17 February 2009

**RE: Proposed Engineered Landfill and Waste Management Facility, Off Old
Wallgrove Road, Eastern Creek - Project No. 06 – 0139 – Light Horse Business
Centre (The Quarry Pty Ltd).**

ATTACHMENT A

Site Plan

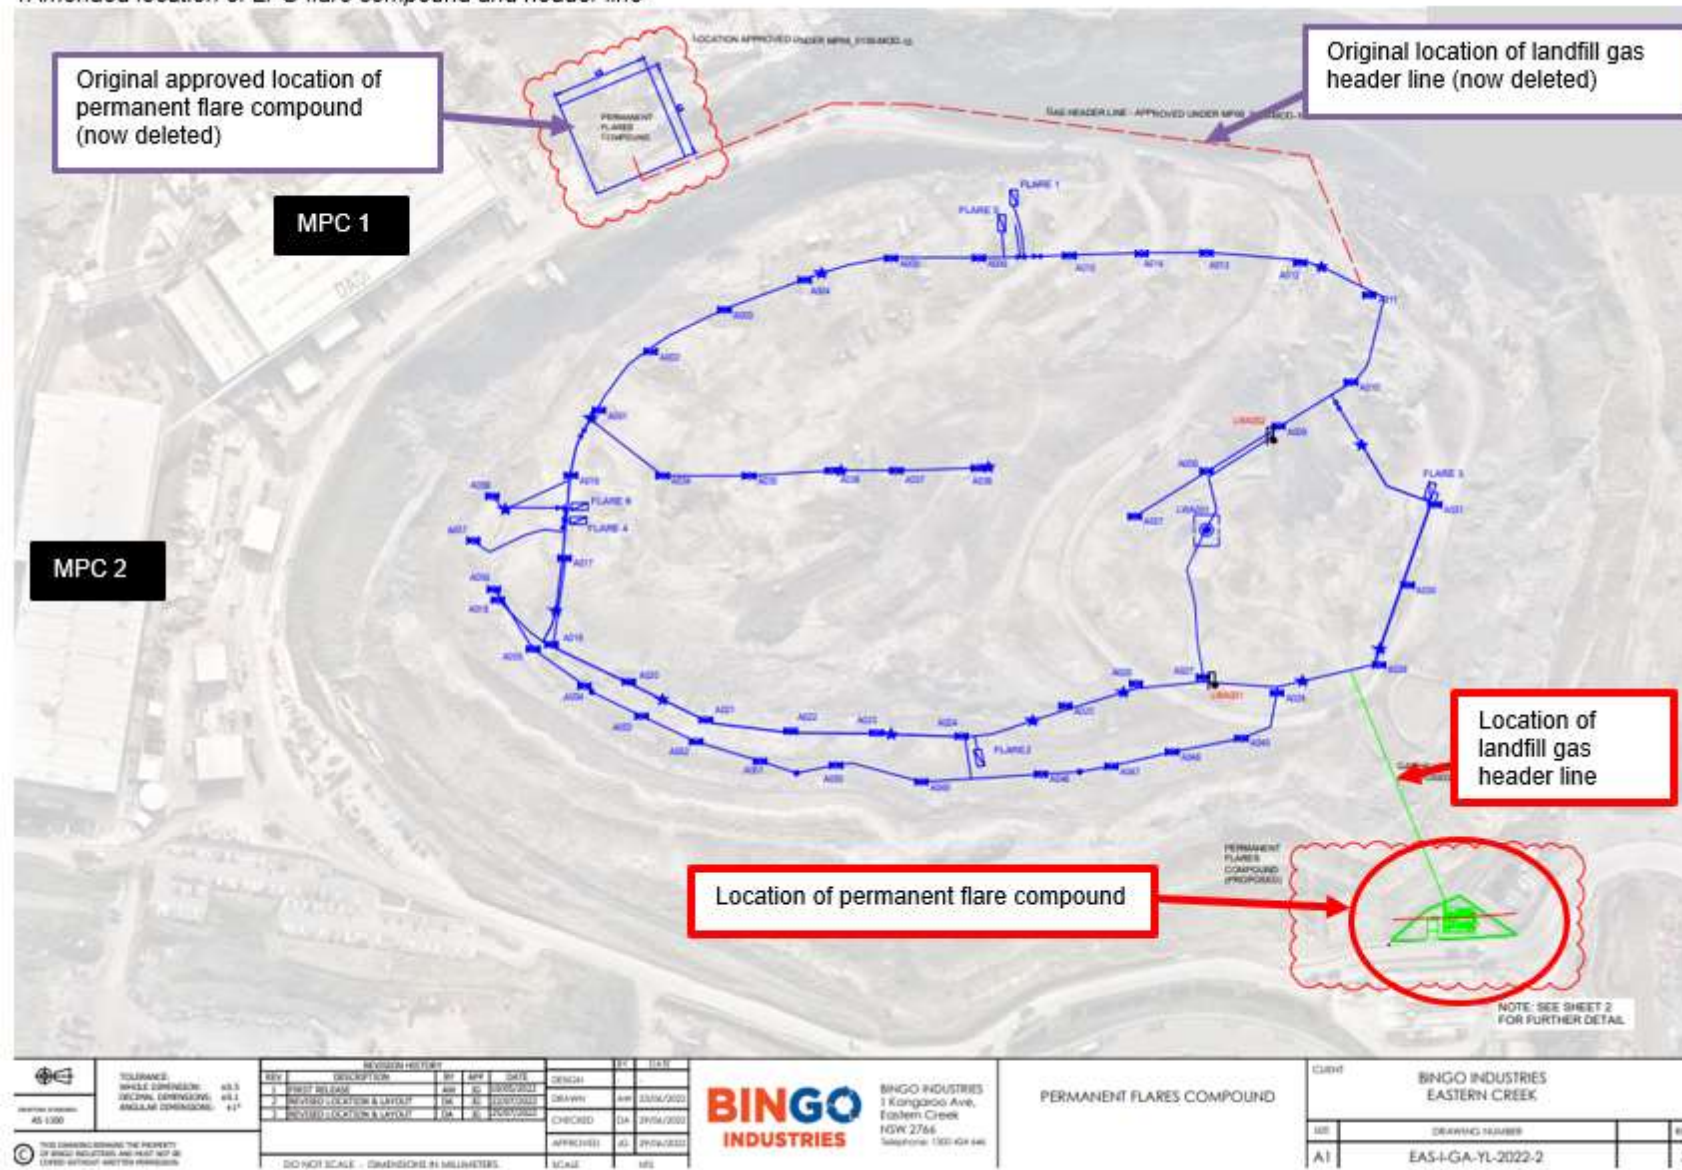
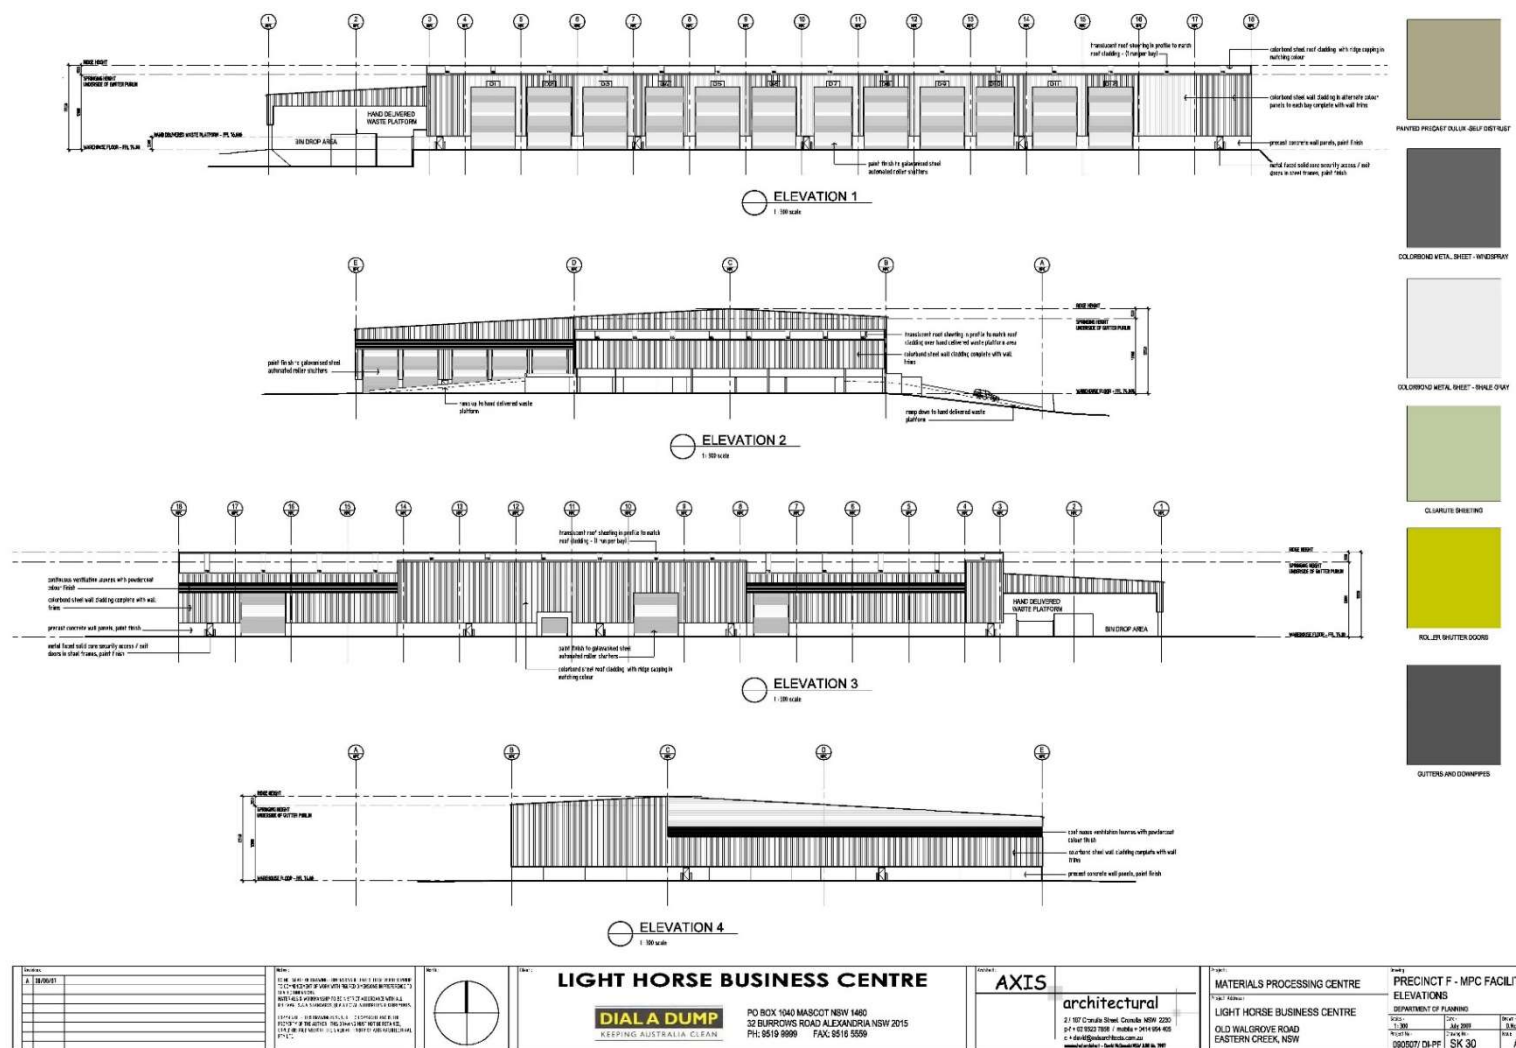
- (a) The provision of a temporary stockpile storage area for after hours deliveries in the vacant area adjacent to the west berm at the southern boundary of the area of operations (as shown in red on the site plan), to further reduce any potential adverse noise and air quality impacts during night-time operations.

- (b) A gate shall also be provided at the above location in order to restrict after-hours activity and vehicular movement to the designated after hours delivery area only (as shown in red on the site plan) and, further, prevent the Facility from becoming a quasi 24 hour operation. An operational condition shall be inserted requiring the site to be secured, and the gate to be locked, at all times outside the approved hours of operation and any after hours operations shall be strictly confined to this designated area. It is considered inappropriate for this land to be set aside for future sub-letting or future development as to do so would prevent the development operating in the manner outlined above.

4. The following plan amendments, as shown in red on the attached site plan, shall be made in order to satisfactorily control the development and adequately address issues in relation to the amenity of surrounding residential areas, such as noise and air quality:

- (a) Provision shall be made for a temporary stockpile storage area for after hours deliveries in the vacant area adjacent to the west berm at the southern boundary of the area of operations, to further reduce any potential adverse noise and air quality impacts during night-time operations. Details of the hardstand to be provided in this temporary stockpile area are also to be provided to the certifying authority and shown on the Construction Certificate drawings.

- (b) A gate shall be provided at the location shown in order to restrict after-hours activity and vehicular movement to the designated after hours delivery area only (as shown in red on the site plan) and prevent after hours use of the Facility. An operational condition shall be inserted requiring the site to be secured, and the gate to be locked, at all times outside the approved hours of operation.

6. Prior to the issue of any Construction Certificate, details of the bitumen all weather sealing to be provided along the entire route to, and in, the quarry void and to the temporary stockpile area designated for after hours deliveries with stockpile areas/work floor areas being in a suitable all weather surface (as shown highlighted on the site plan) to mitigate potential dust problems are to be submitted to the certifying authority.
